DECISION DELEGATED TO HEAD OF PLANNING

Application No: H05-0218-22 **Applicant:** Mr & Mrs A Verrells

Proposal: Conversion, partial demolition and extension of barn into a new dwelling - approved under H05-1038-21. Modification of Condition 2 to allow amendments to previously approved plans.

Location: Poplar Farm Moor Gate Holbeach

Drawing **Planning (Garage)**

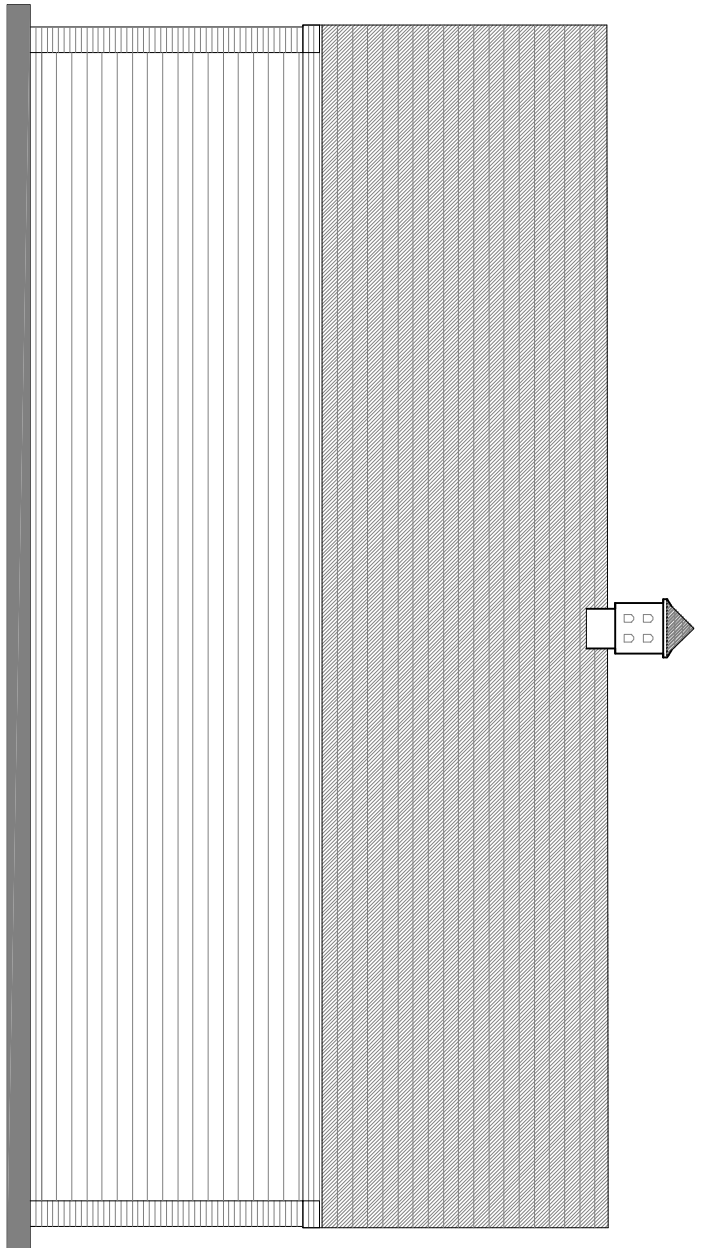
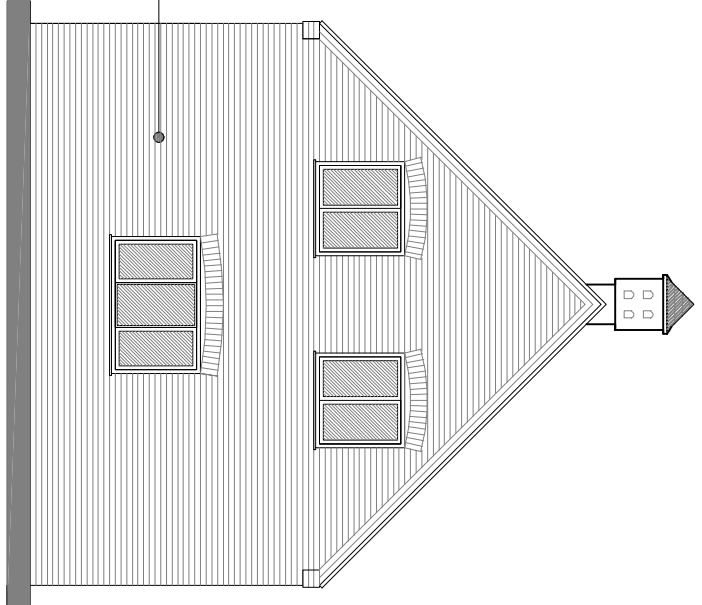
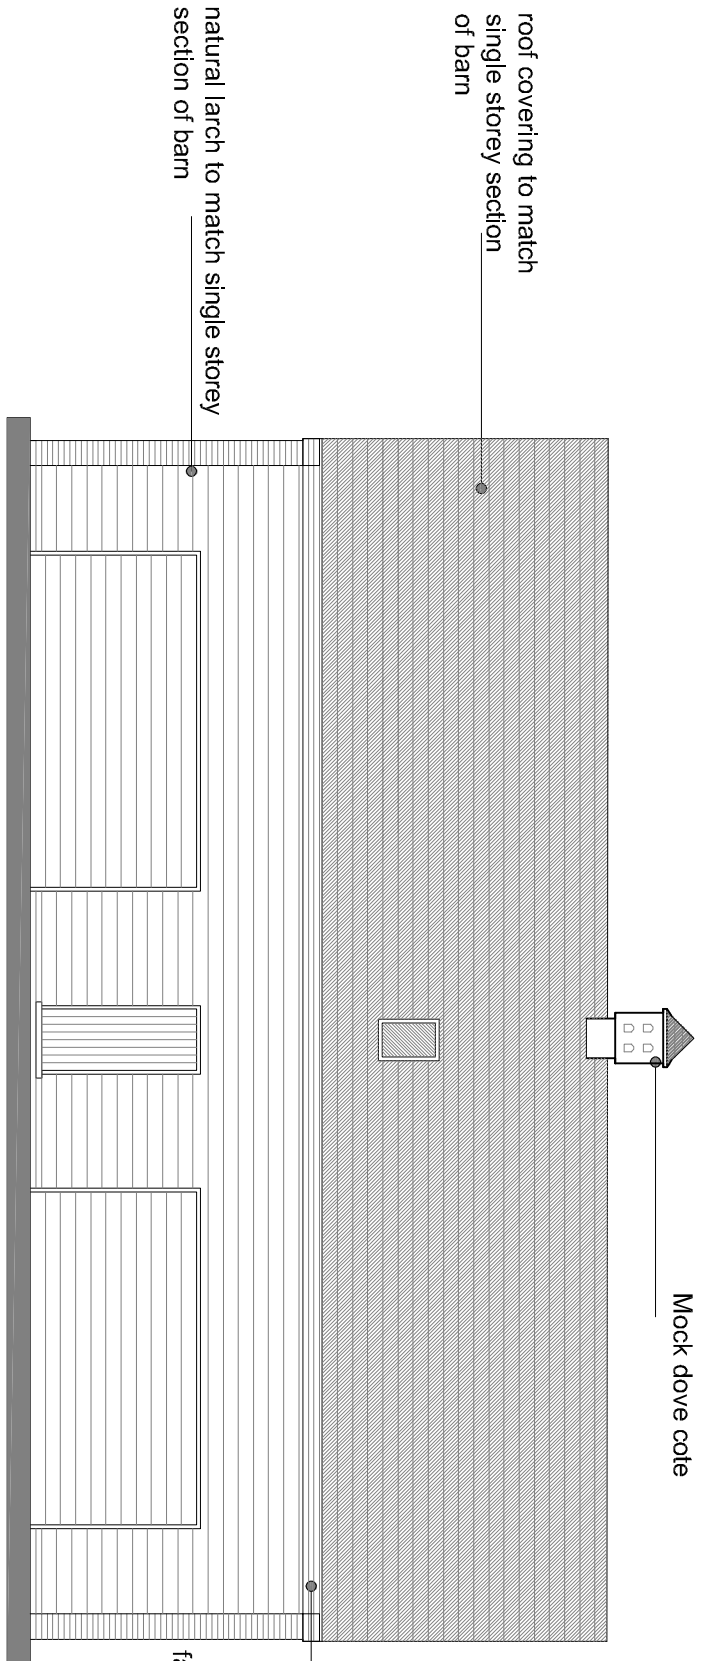
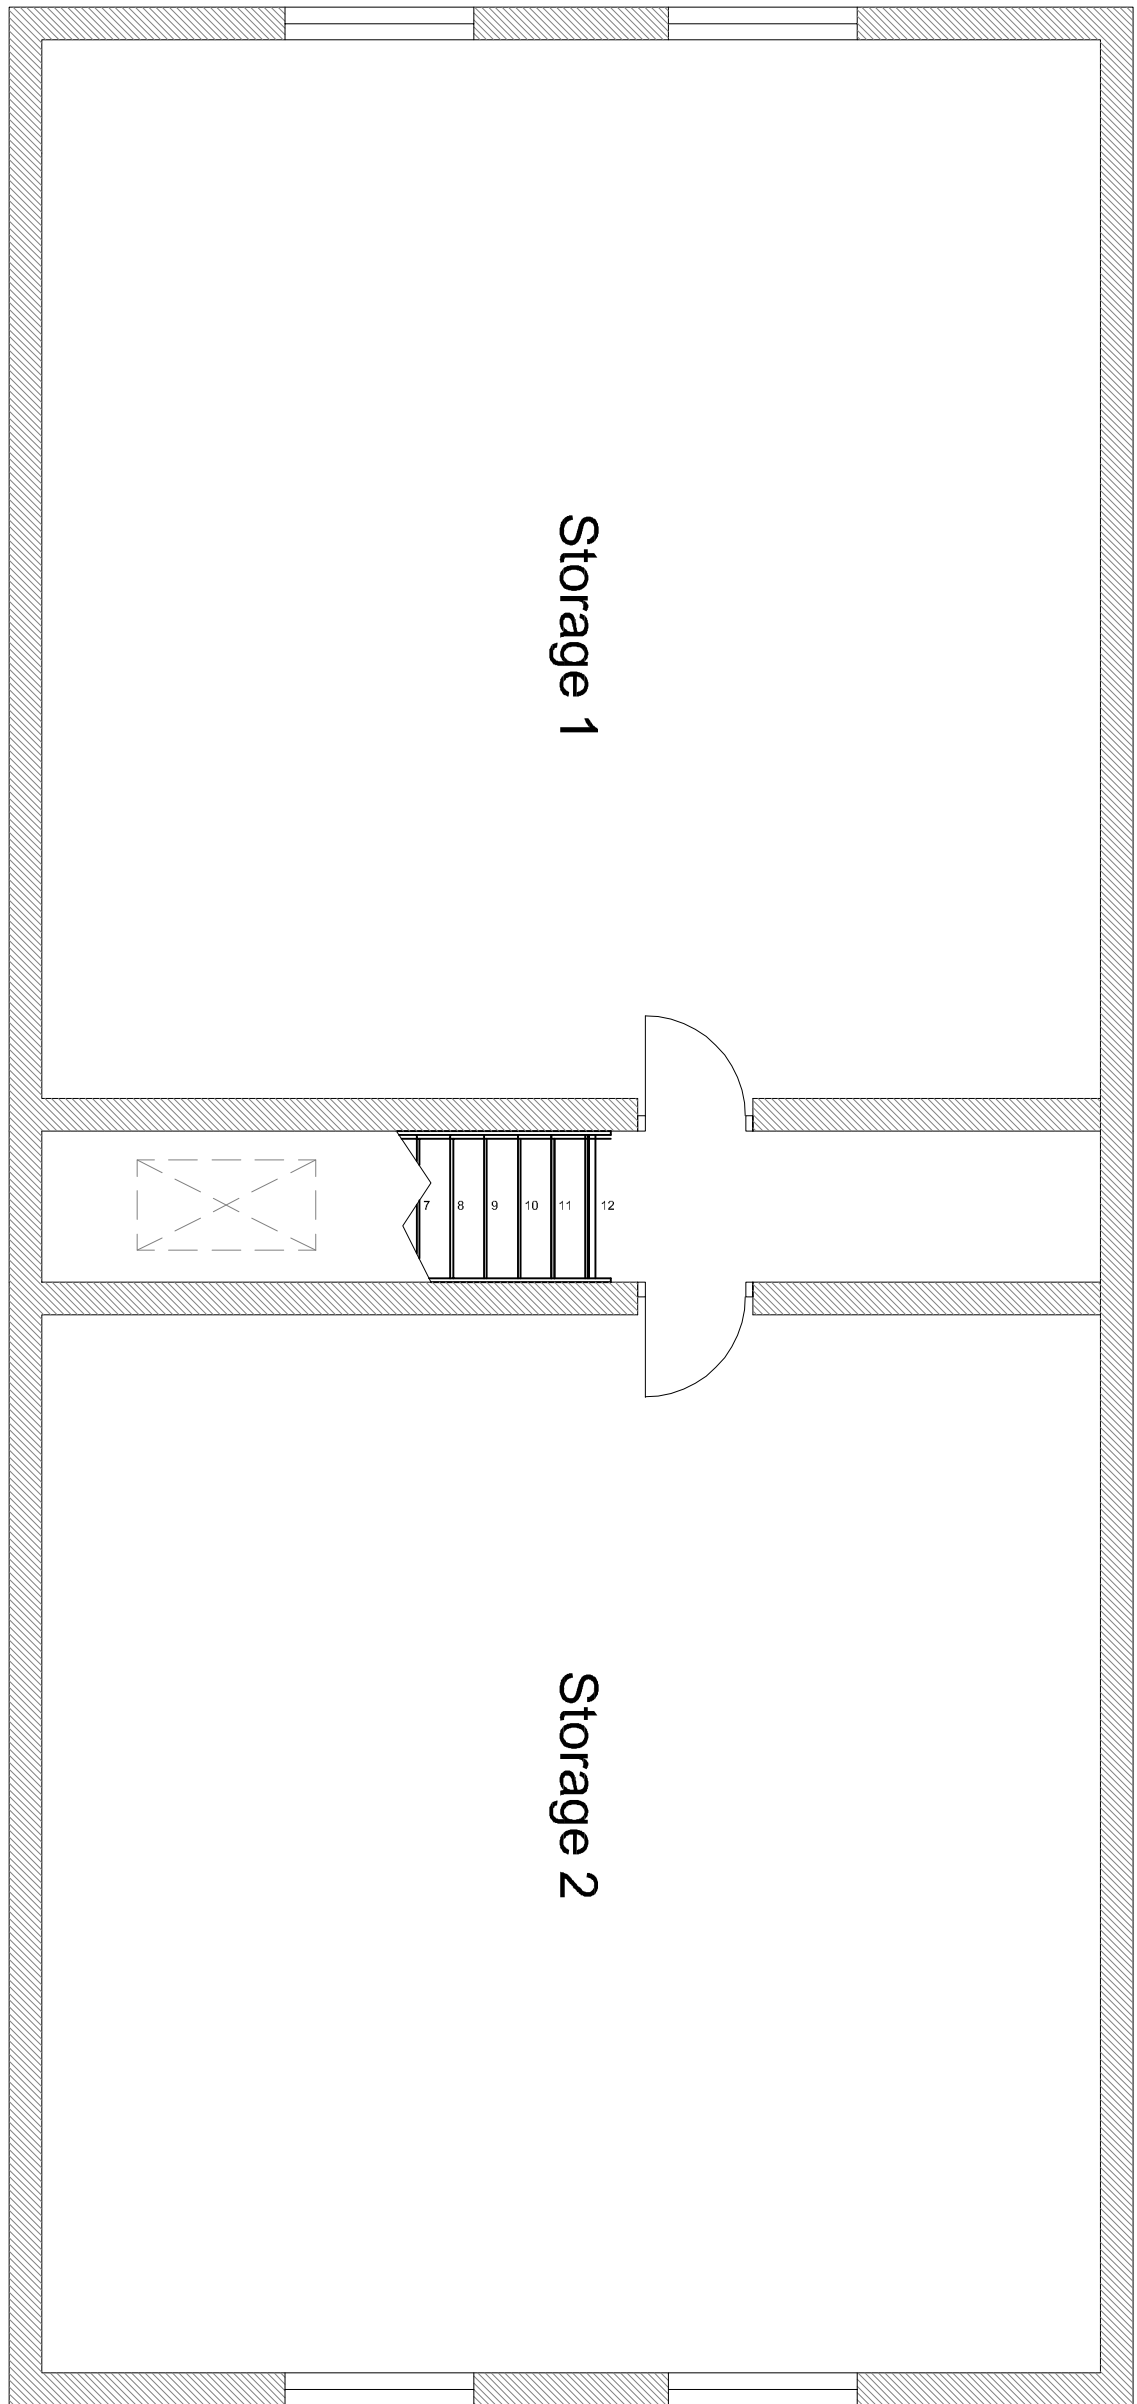
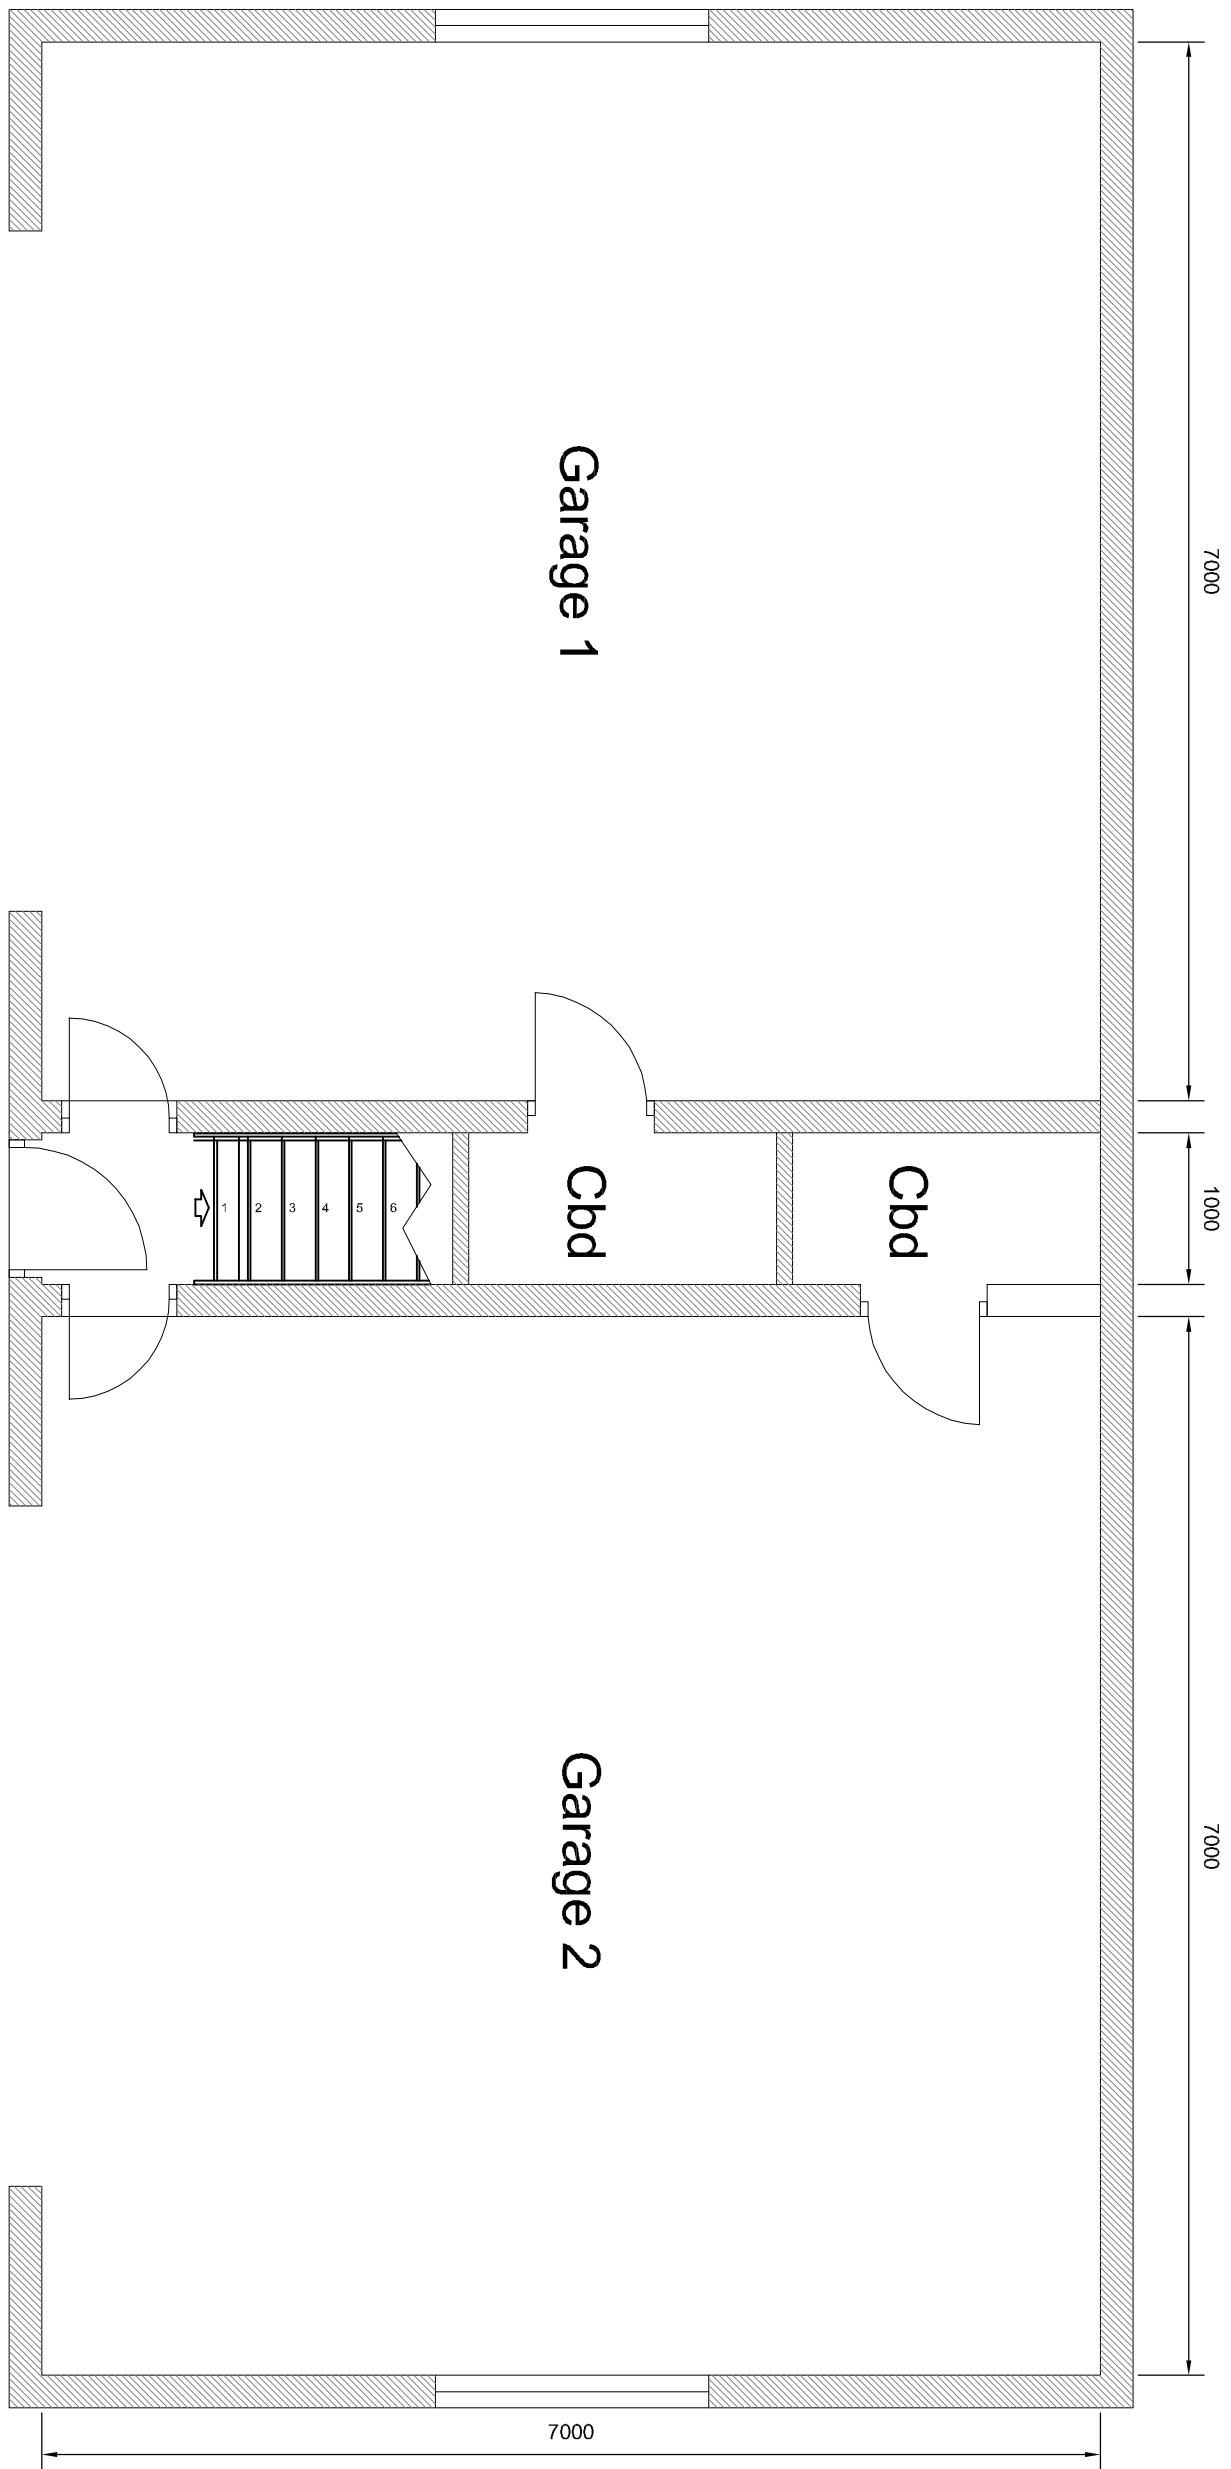
- Larch board to the front and rear elevation to match stable section.
- Addition of a second first floor window to both side elevations.
- Increase in width of the ground floor windows.

The proposed larch board reflects that of traditional timber agricultural buildings in the countryside. The revisions to the fenestration are considered to be relatively minor and would not materially harm the character or appearance of the building or rural locality.

In terms of amenity, the nearest residential property is a house (The Poplars) to the north-west of the garage. The revision would include an additional window on the first floor of the garage facing north to north-east. It serves a storage area. The nature of the use and also the distance from and orientation with the poplars is such that the amenity of its occupiers would not be materially harmed in terms of overlooking, lack of privacy, etc.
